Rule 17 - Deadline 6 Response

SUBJECT: Viking CCS Pipeline

APPLICANT: Chrysaor Production (UK) Limited

**NORTH EAST LINCOLNSHIRE
COUNCIL**

Figure 1-1: Site Location

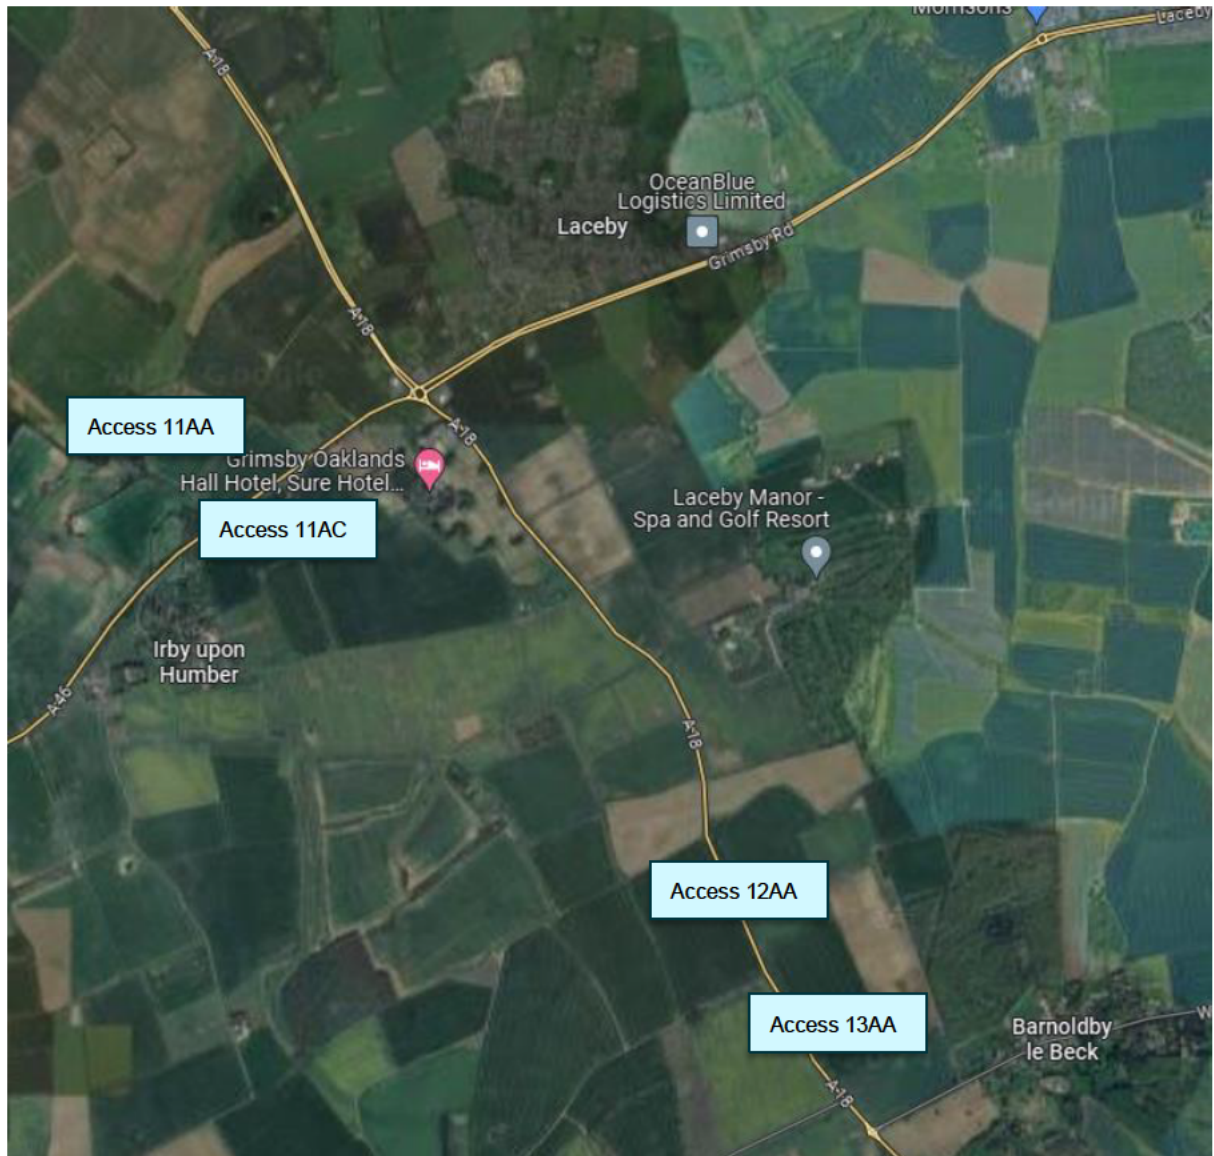
The document in our possession at point 1.2.2 shows a map of the general area in which the scheme is located. This map identifies 4 locations access 11AA, 11AC, 12AA and 13AA.

3.5.2 suggests signage at locations 10AA, 11AA, 11AC, 12AA and 13AA. This discusses 5 locations when the original map at 1.2.2 identifies 4 locations.

IMAGE: Extract from 60718962-ACM-GEN-ZZ-DR-CH-0005 showing swept path analysis for Access 13AA.

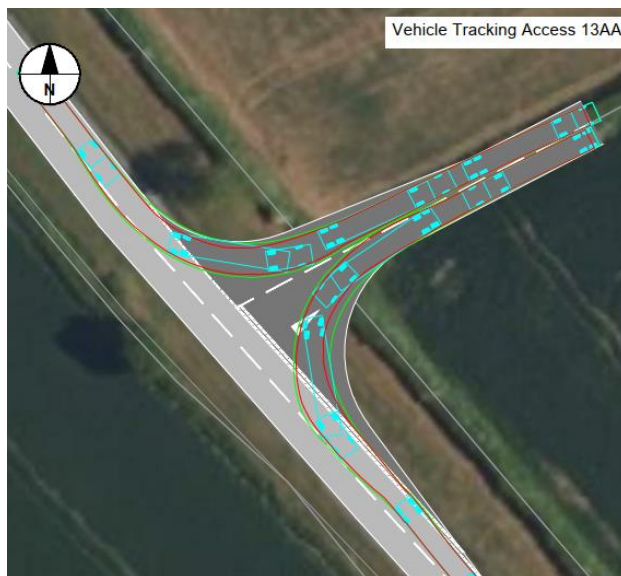
3.1.2 identifies access 13AA specifically.
